**Hullavington Parish Council
Closing Statement**

**Lime Down Solar Farm: Application Reference EN010168
Deadline 8, 16th October 2026**

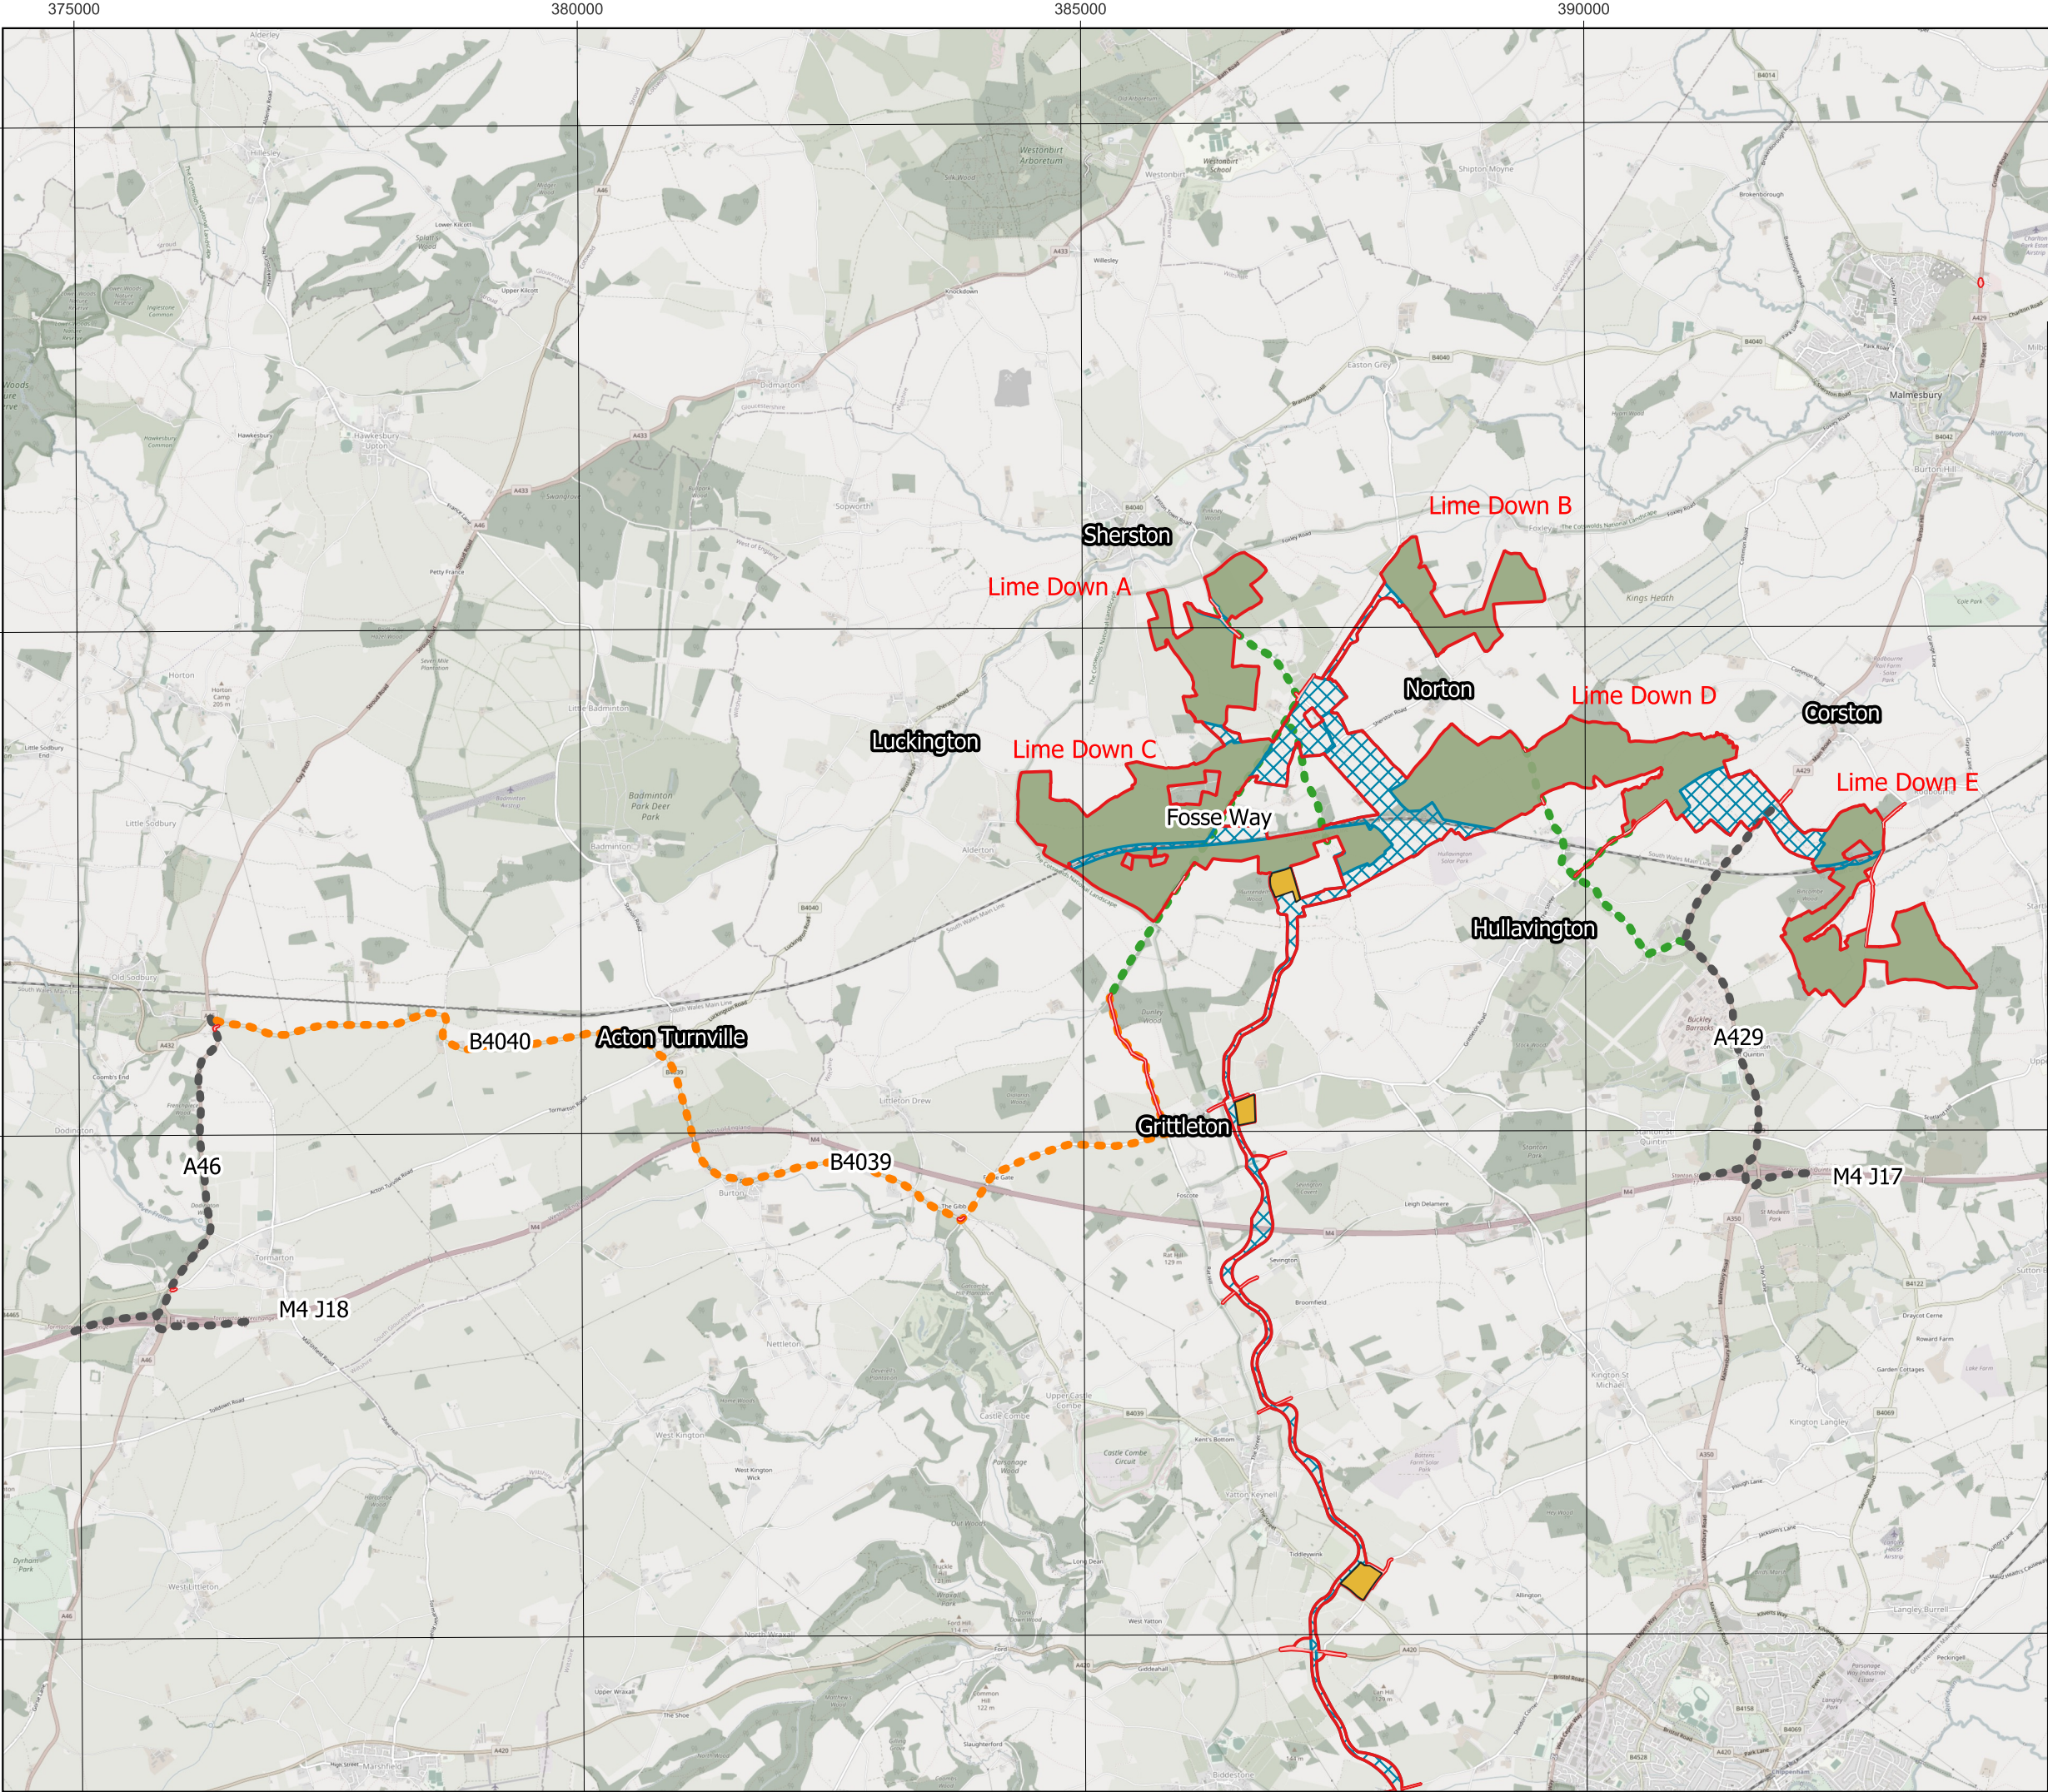
2.4 The Applicant has not answered these points. It classes the section between Hullavington crossroads and Bradfield Cottages as "Low" sensitivity because, in its view, the section contains no additional receptors beyond those between the A429 and the crossroads. That is a classification exercise. It does not answer the highway safety question the highway authority has asked.

3.1 The classification is also wrong on its own terms. The three-quarter mile section either side of the railway bridge is the shortest and, in most cases, the only route for pedestrians between ten well-used footpaths, tracks and entrances: footpaths HULL4, HULL5, HULL8, HULL9 and HULL29; the track to footpaths HULL6 and HULL7; the entrance track to the Flying Monk Café and Tap; the entrance to Brookside housing; the entrance to the cottages by the Old Railway Yard; and the permissive footpath immediately south of the railway bridge.

APFP Regulation: APFP Regulation: 5(2)(a)
Application Doc no.: APP /6.2
Drawing no.: Figure 13-11

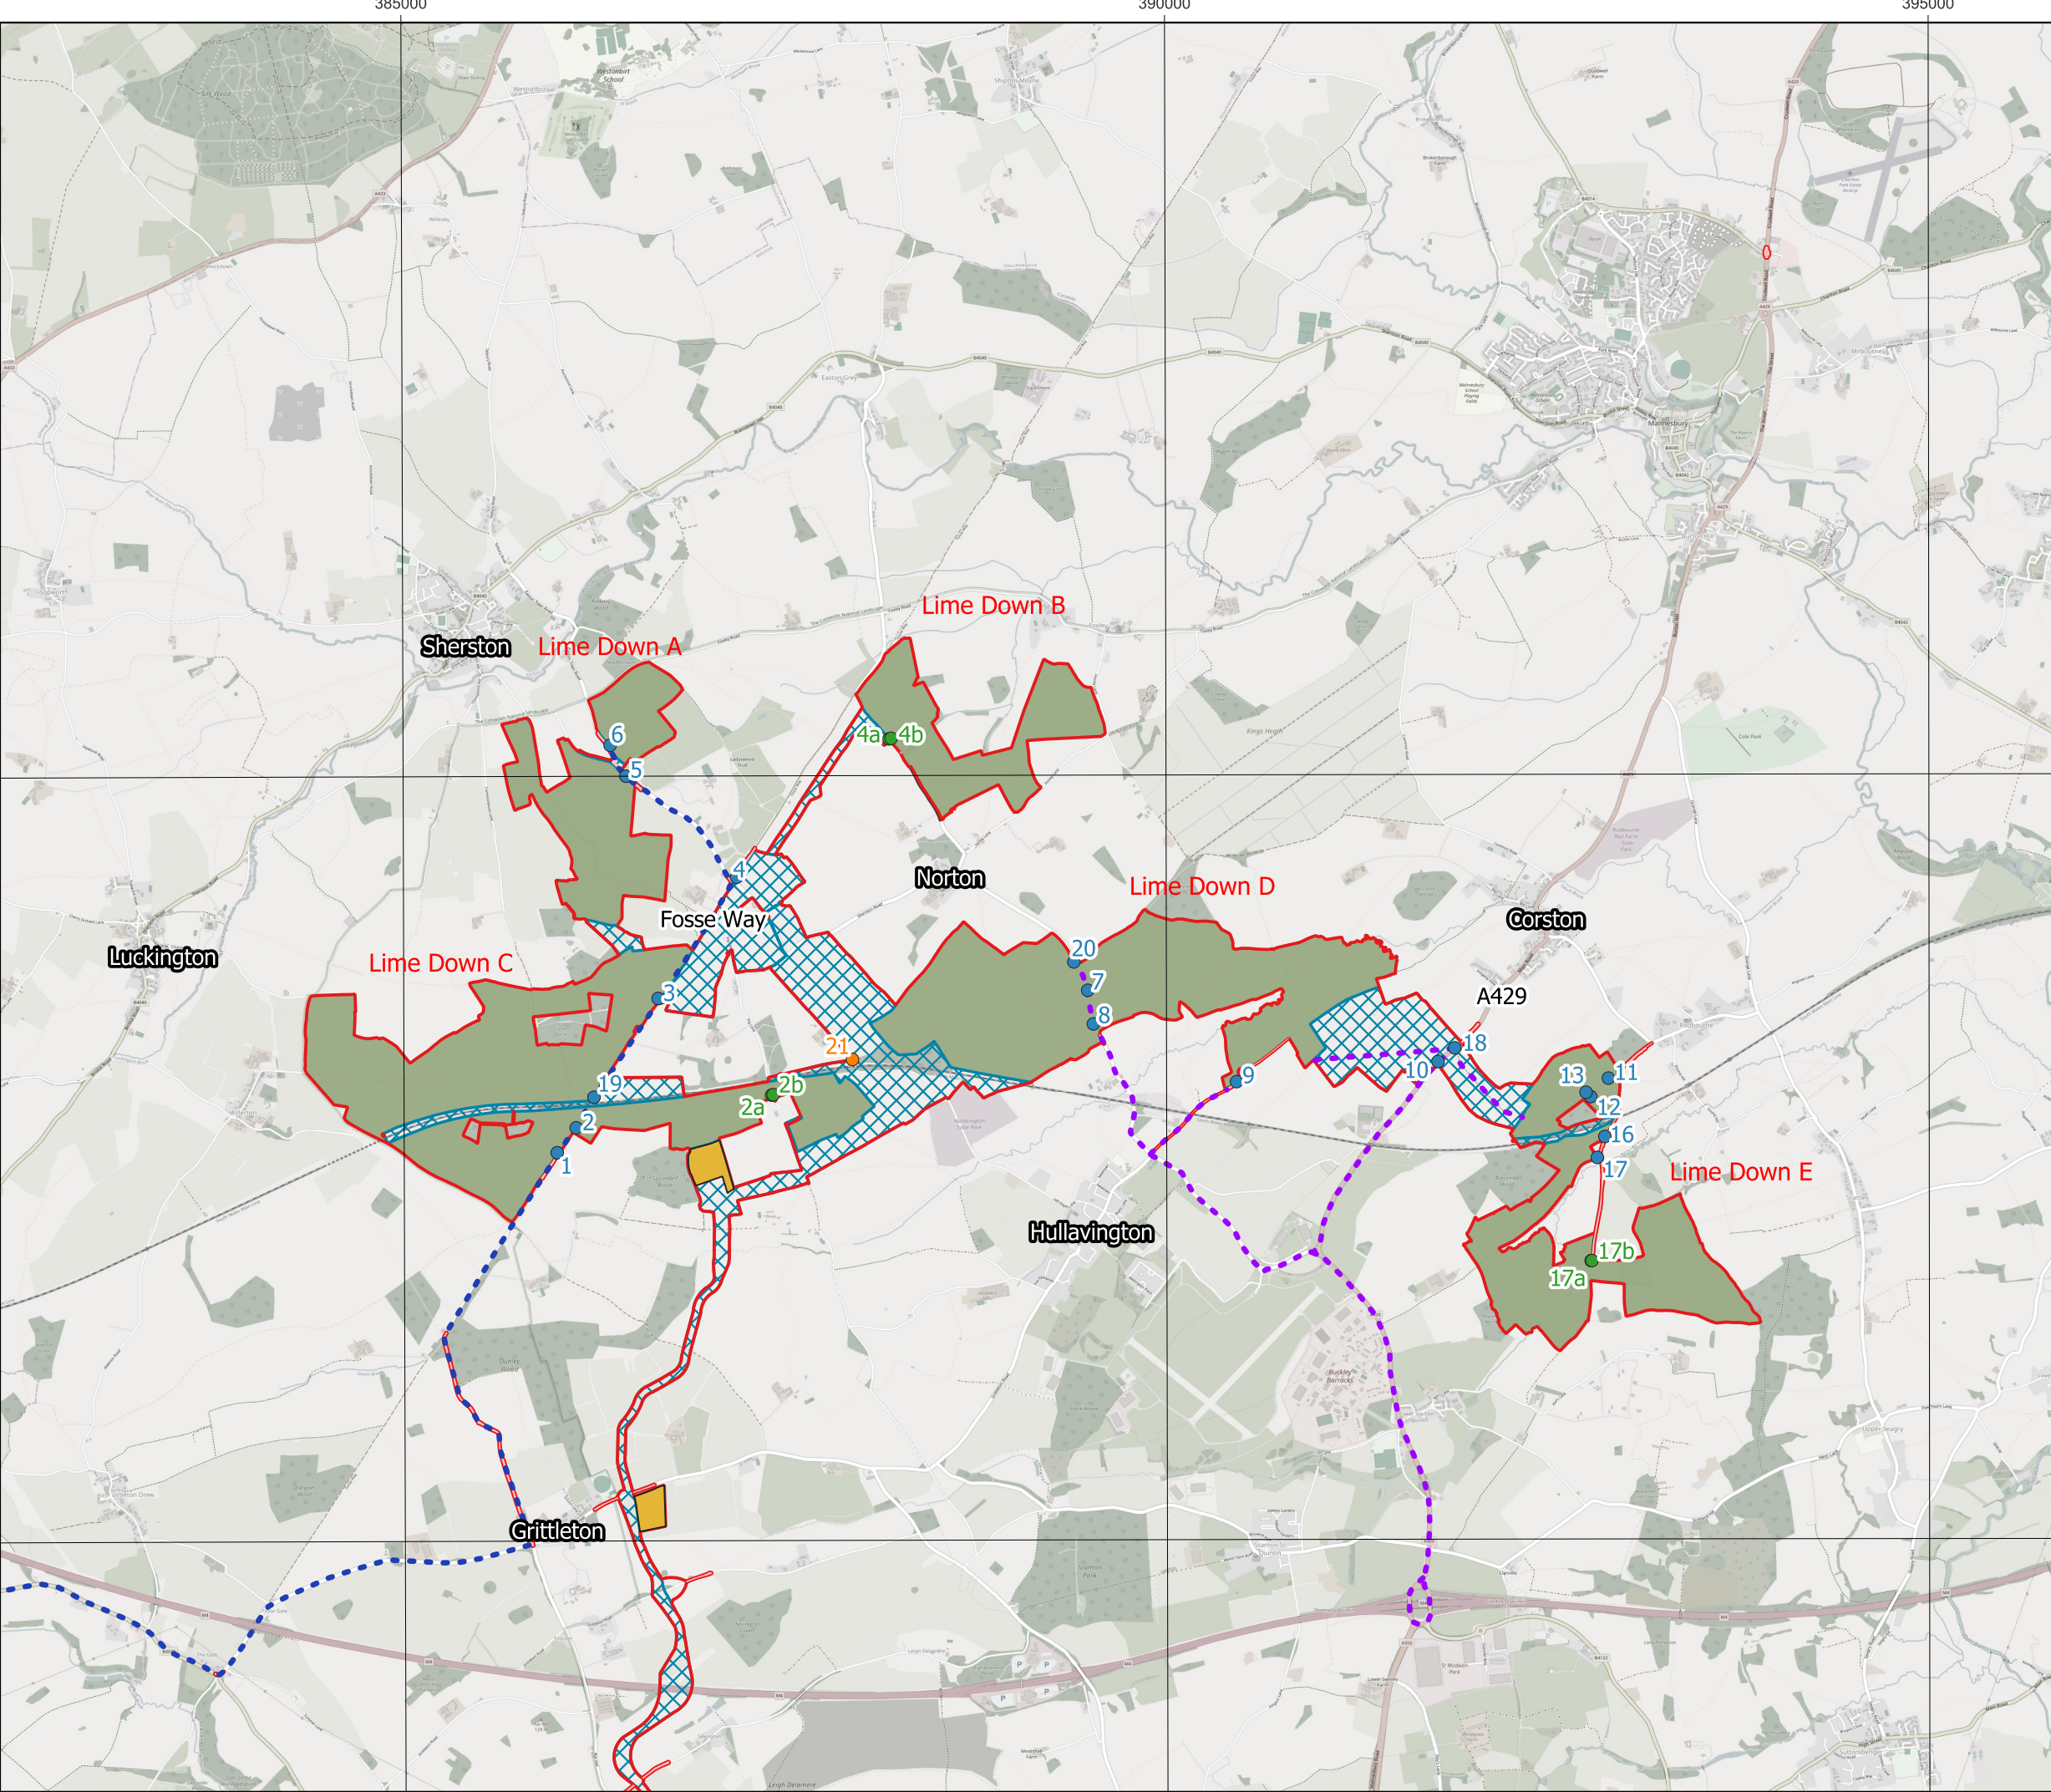
2.1 In the Statement of Common Ground with Wiltshire Council (Rev 5) [EN010168/APP/8.2], Wiltshire Council states that the sensitivity classification of the construction routes to Lime Down Sites A–C and D–E "does not address highway safety or operational impacts". It states that evidence is still required to demonstrate adequate passing opportunities for two HGVs along the entire access route.

2.2 Wiltshire Council also disagrees with the Applicant's assessment of minor adverse impacts on the Fosse Way. It cites the narrow carriageway and long sections with limited passing opportunities. It notes that the route from Dyson Roundabout to Bradfield Cottages has not been assessed, despite predicted high HGV flows and concerns about two-way HGV passage, "particularly northwest of the Hullavington crossroads".

4.1 The Applicant's response to Wiltshire Council's concerns about passing opportunities is widening and passing places. The Parish Council is seriously troubled by suggestions made at the hearing that verges should

- leave pedestrians with nowhere to escape when confronted by vehicles;
- reduce visibility further for people walking towards the village, because the road and verge are not straight and oncoming vehicles would be out of sight;
- create a new pinch point at the railway bridge, which cannot be altered, where large vehicles already pass in the centre of the road and come into conflict with traffic from Norton;
- add to the existing hazard at Brookside, where visibility towards the village is already so poor that drivers must wind down their windows to listen for traffic; and
- encourage faster driving on a road where speed is already a principal danger.
